DRAFT APPLICATION FILE

MISSING INFORMATION SCHEDULE (March 2015)

Figure 2.1: Transmission Systems in Ireland and Northern Ireland (2015)

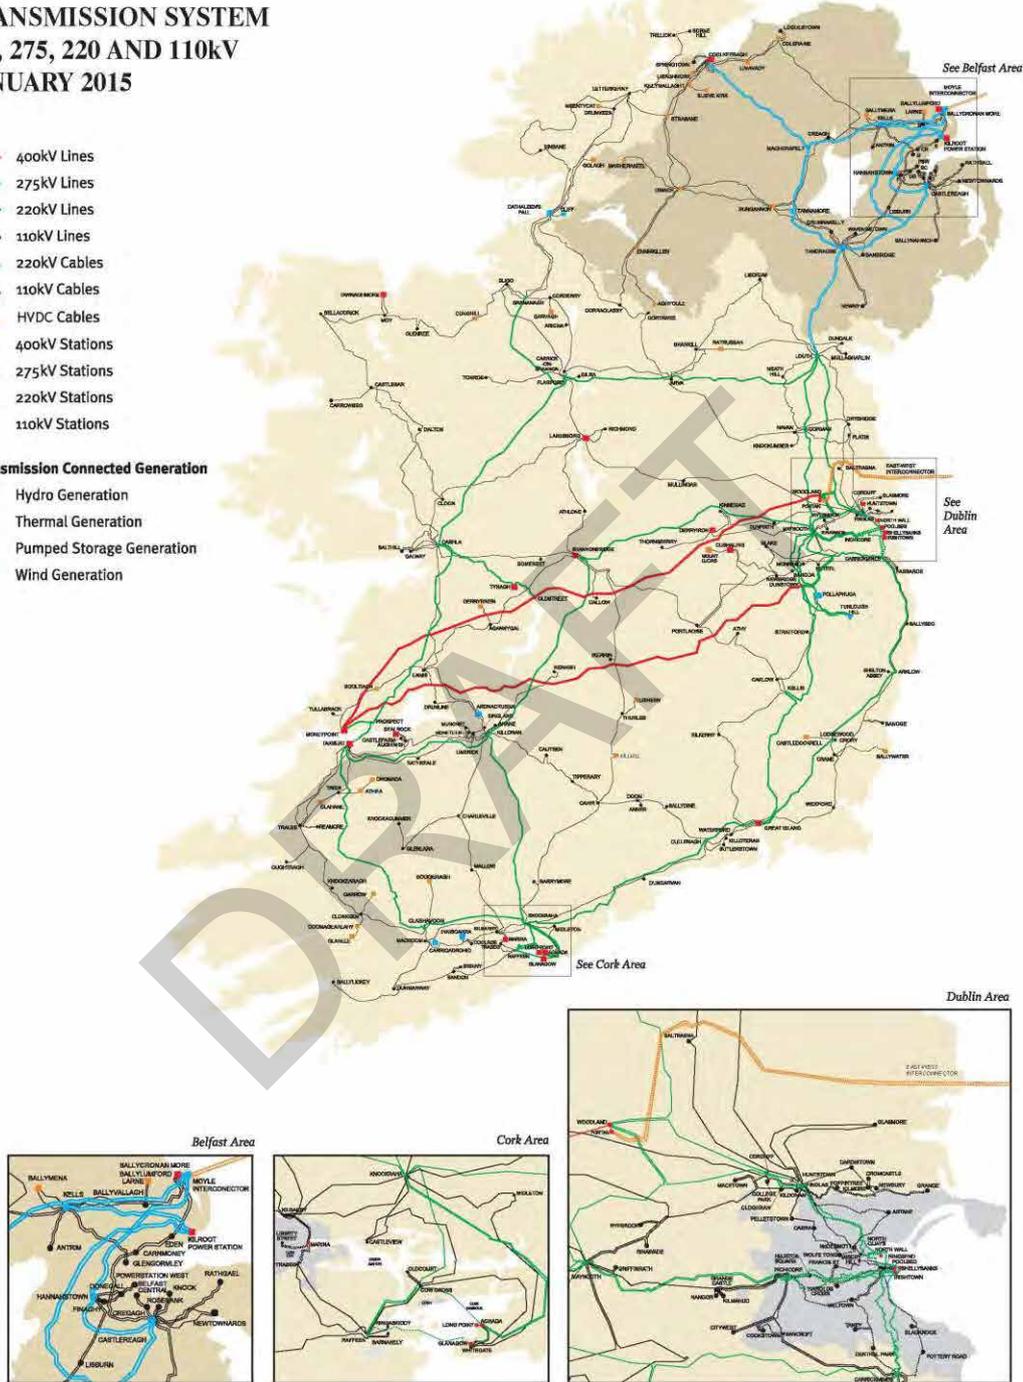
Section	Missing Information Request	Response to Request	Location of Missing Information in DAF (March 2015)
	<p>Correct reference to "Error! Reference Source not found." in paragraph 1 of pages 14-21 of Vol. 3C</p>	<p>The 'Error' reference has been removed.</p>	<p>N/A</p>
	<p>The EIS should ensure that all figures and illustrations contained in Volumes 3A – 3D are fully legible. This relates in particular to the following:</p> <ul style="list-style-type: none"> • Figure 2.1 on pages 2-4 of Volume 3B. • Figure 6.1 on pages 6-3 of Volume 3B. Figure 7.10 on pages 7-22. • Figure 4.1 on pages 4-19 of Volume 3B. 	<p>All figures and illustrations contained in Volumes 3A to 3D of the EIS have been reviewed and replaced with higher quality images where necessary.</p>	<p>Figure 2.1, Chapter 2, section 2.3.1, Volume 3B has been replaced.</p> <p>Figure 4.1, Chapter 4, section 4.6, Volume 3B has been replaced.</p> <p>Figure 6.1, Chapter 6, section 6.2.1, Volume 3B has been replaced. An A3 version of the figure is also provided in Volume 3B Figures.</p> <p>Figure 7.10, Chapter 7, section 7.3.4.4.1, Volume 3B has been replaced. An A3 version of the figure is also provided in Volume 3B Figures.</p>

Figure 13.1: Indicative Corridors of the Proposed Leinster Orbital Route

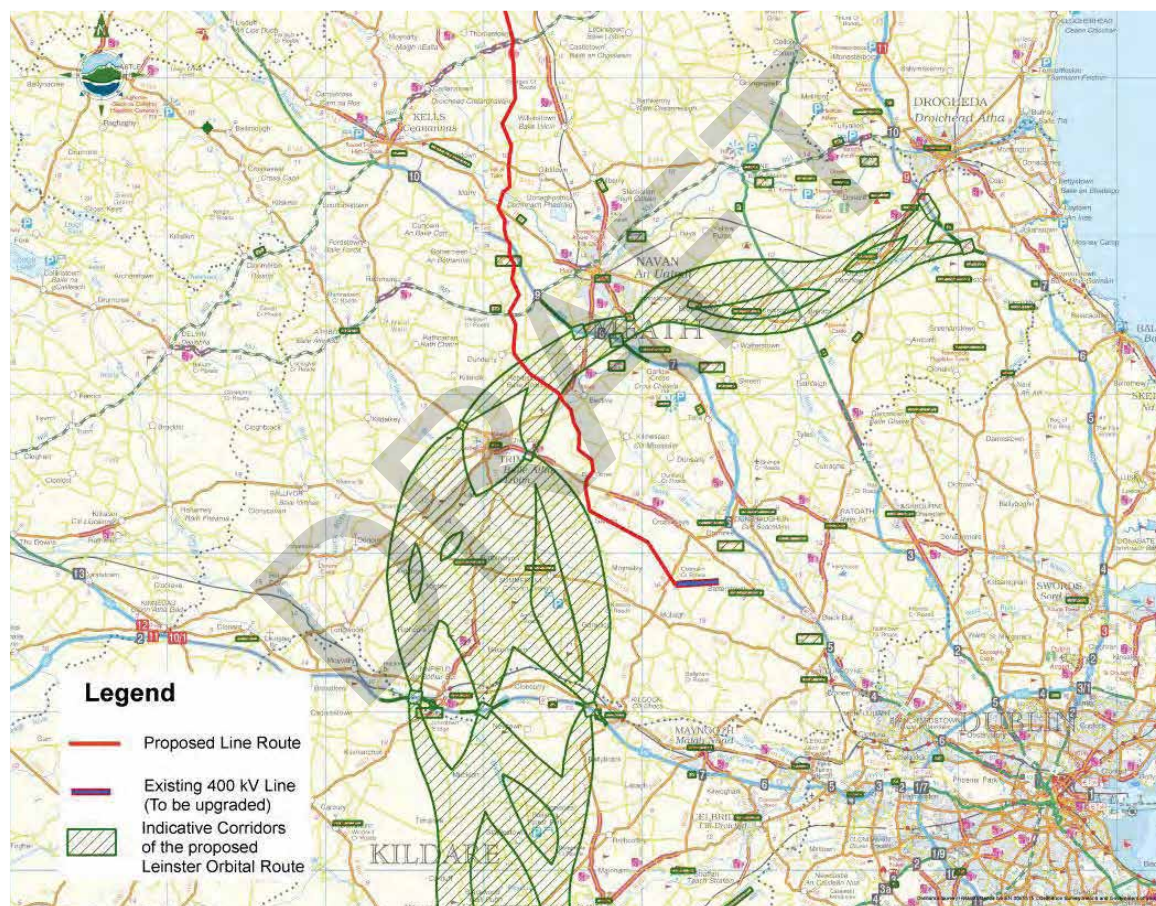
Section	Missing Information Request	Response to Request	Location of Missing Information in DAF (March 2015)
			Appendices of the EIS.
2.5.7 Material Assets (Scoping Opinion Ref: 5.6)	The indicative route of the proposed Leinster Orbital Route and relationship with the proposed development should be identified, based on best available information.	New figure added to show the relationship of the indicative corridors of the proposed Orbital Route with that of the proposed North-South 400 kV Interconnection Development.	New Figure 13.1 entitled ' <i>Indicative Corridors of Proposed Leinster Orbital Route</i> ' added to section 13.4.4, Volume 3D of the EIS.
	Confirm where, if any, re-routing of existing overhead lines will be required.	New report entitled <i>North-South 400 kV Interconnection Development - Identification and Resolution of Conflicts with Overhead Line Infrastructure (2015)</i> provided.	Report entitled <i>North-South 400 kV Interconnection Development - Identification and Resolution of Conflicts with Overhead Line Infrastructure (2015)</i> provided as Appendix 7.3, Volume 3B of the EIS.
